PCU048850

1 October 2013

Modification Application for Sites 2A and 3A, 40-42 & 44-46 Walker Street, Rhodes (MP 10_0105 MOD 3)

Drawing Name
Roof Plan

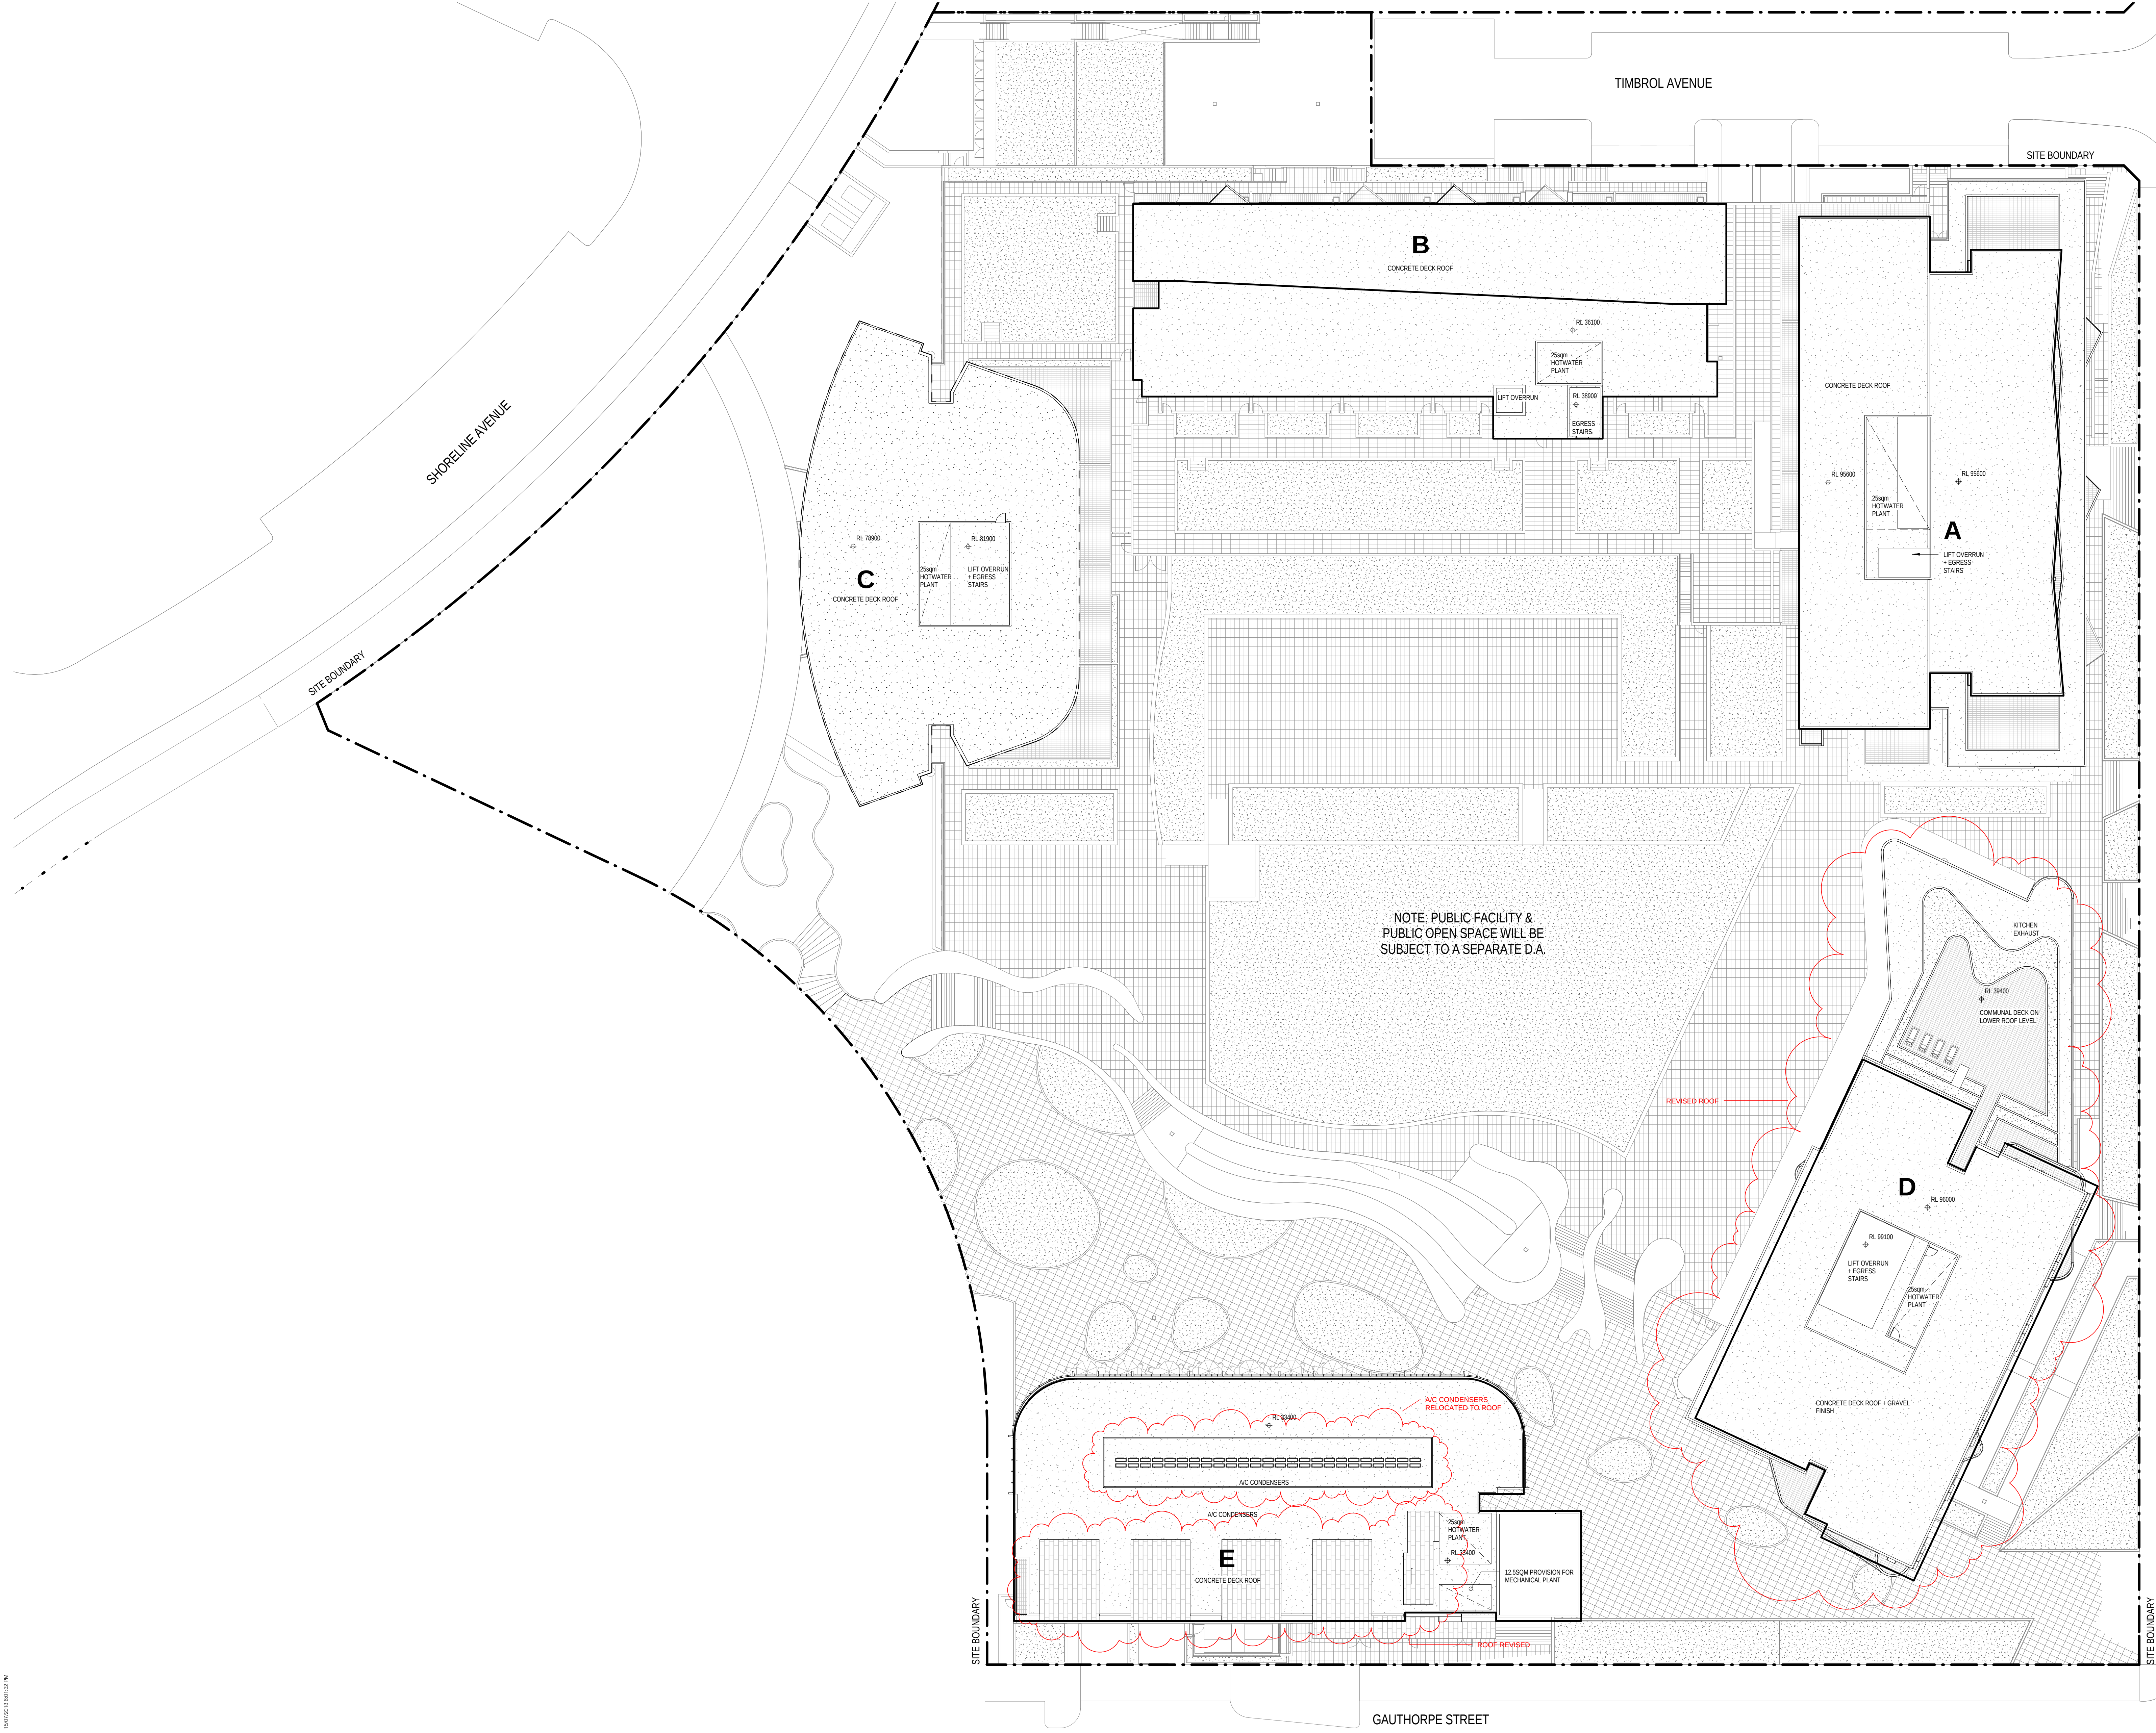
It is also noted that the LEP limits the height of the development to 82m. The proposal (page 27) refers to a height of 84m.

Building C
Wintergarden Overlay

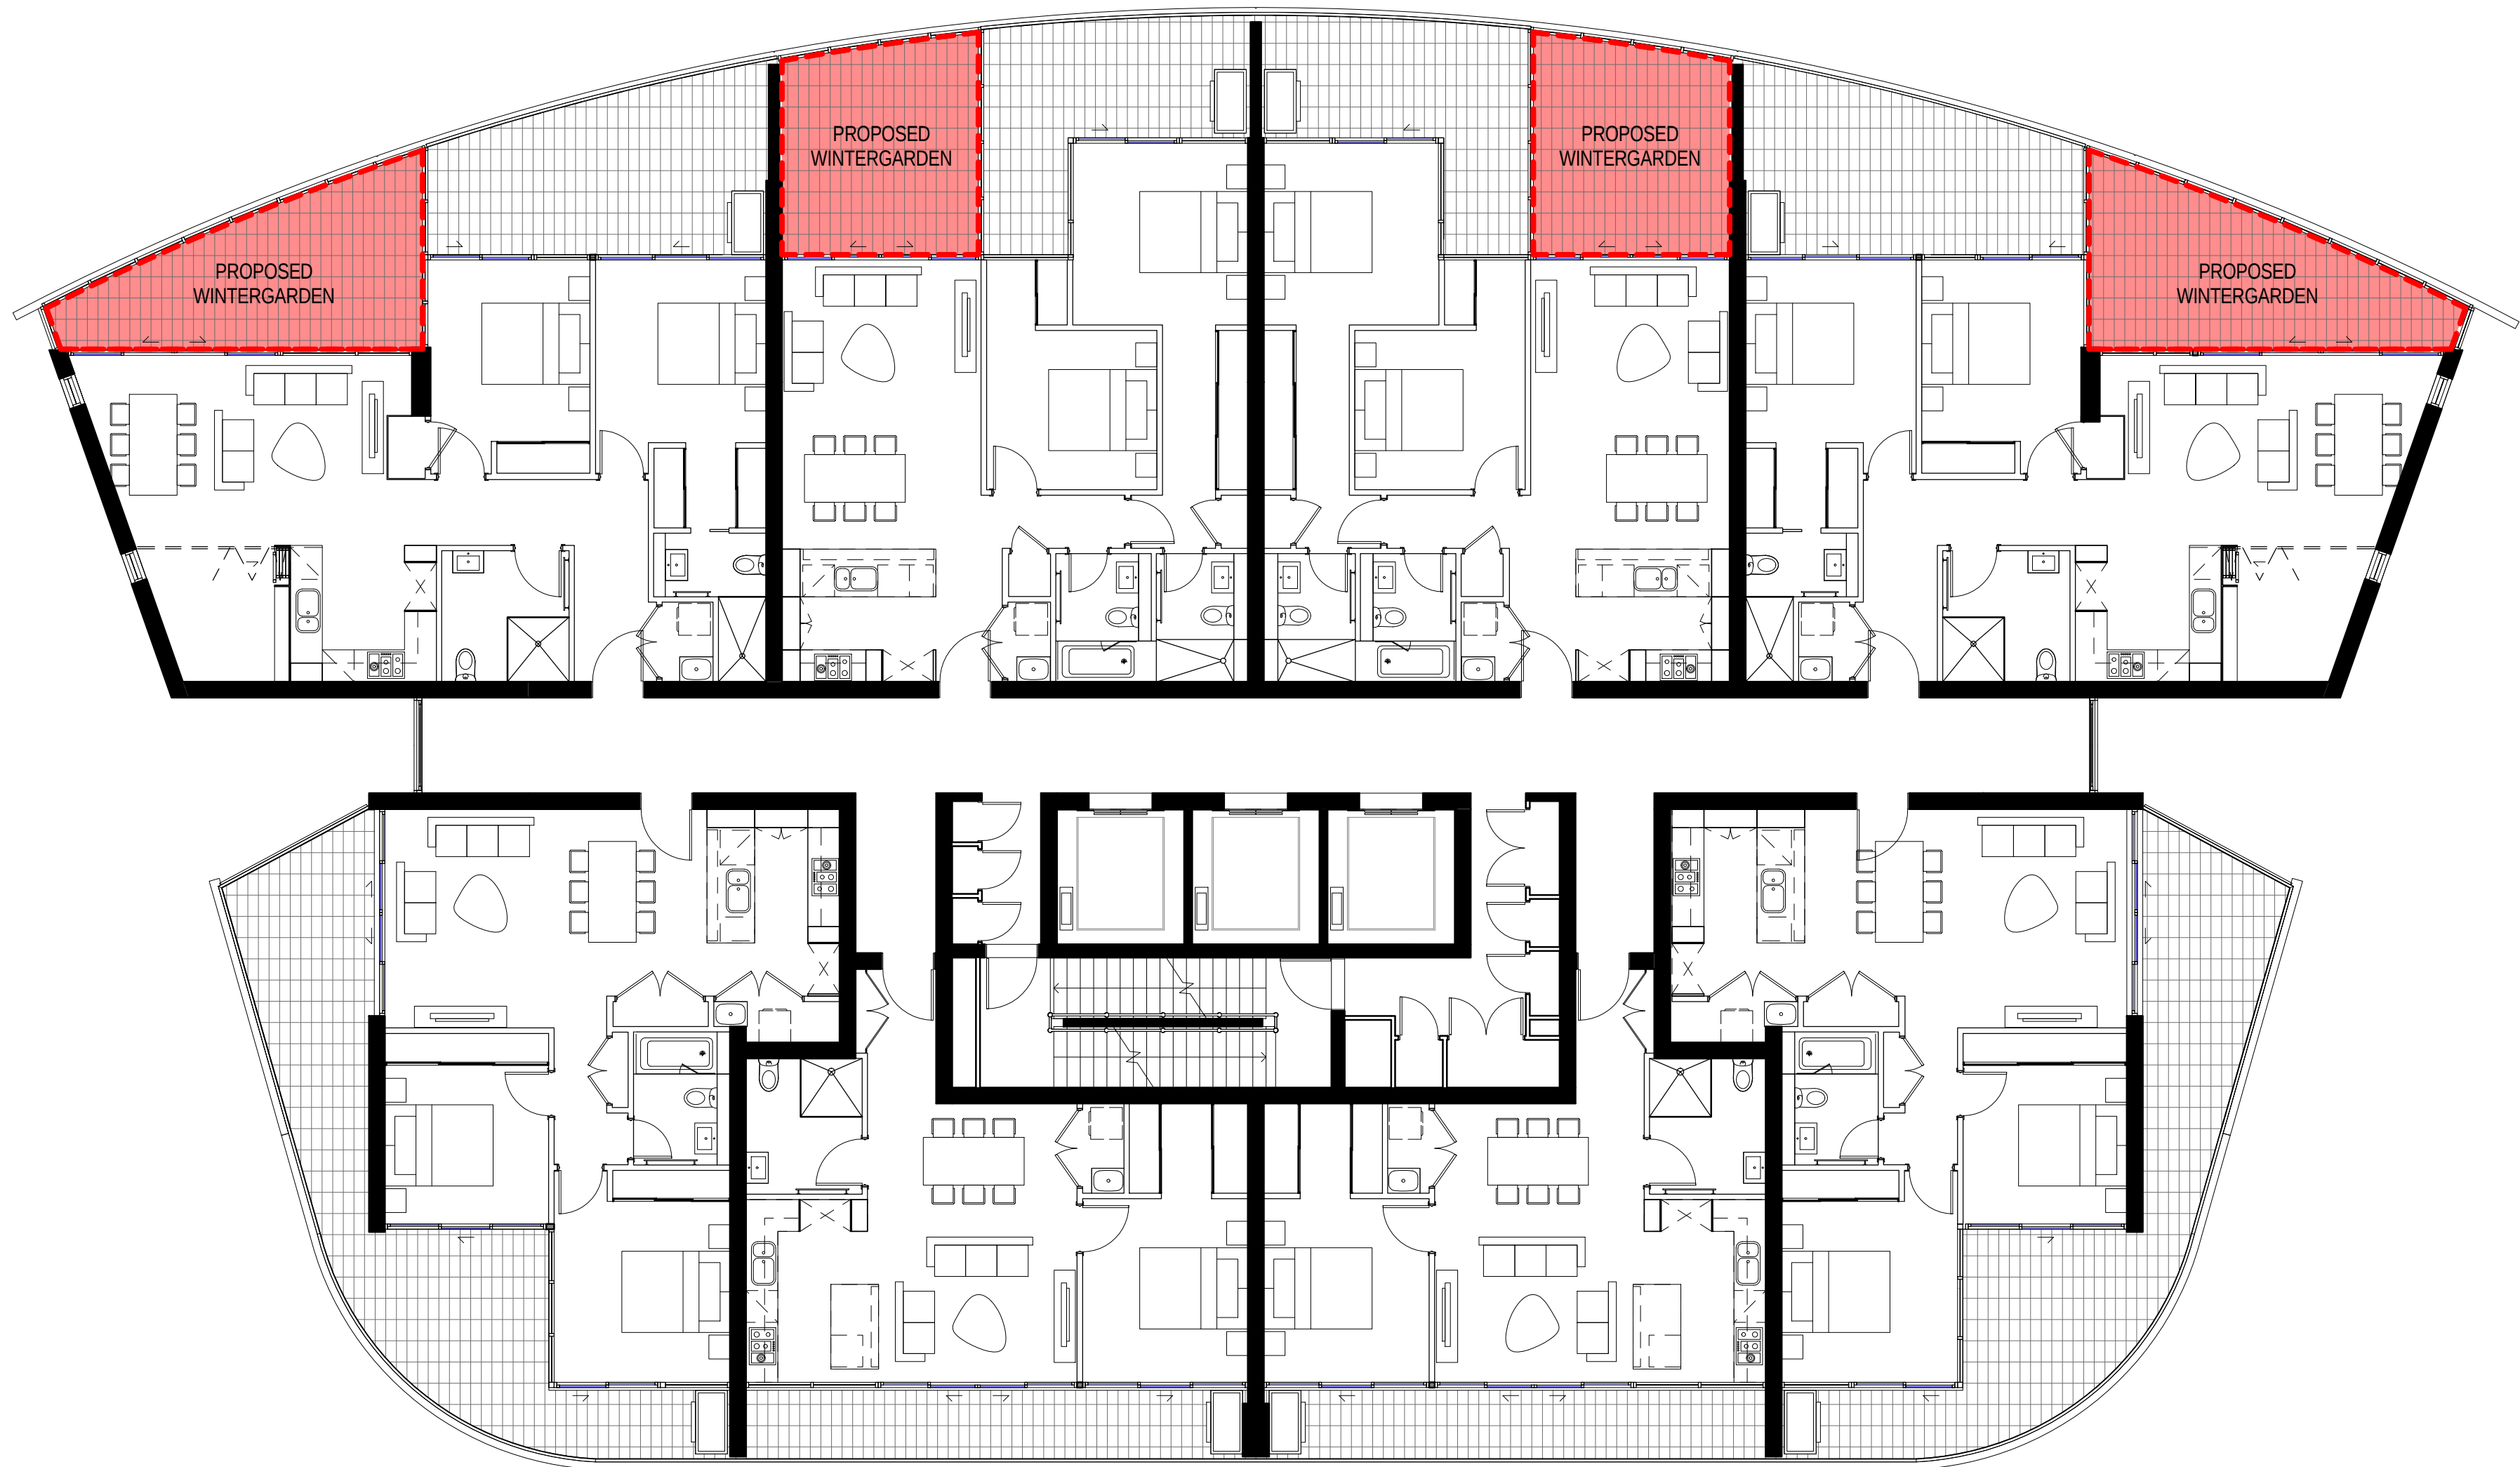
It is incorrect of the developer to argue that the site has spare floor space capacity based on the SREP29 definition of floorspace. Calculations of floor space under both SREP29 and the new current Standard Template definition must be provided so that they can be compared, and so that it can be properly assessed as to whether the 2.8:1 in the LEP has been breached and to what extent. In this regard, it is noted that significant numbers of winter gardens have not been included in the floor space totals, and that if this component is added (as it should be), then the amount of variation of floorspace from that which was approved, is considerably greater than is currently appreciated in the Modification Report. Both calculations based on the two definitions should be requested so that they can be compared, understood and properly assessed. In other words, it is necessary to compare "apples with apples" when considering the floorspace limit, and the winter gardens should not be excluded.
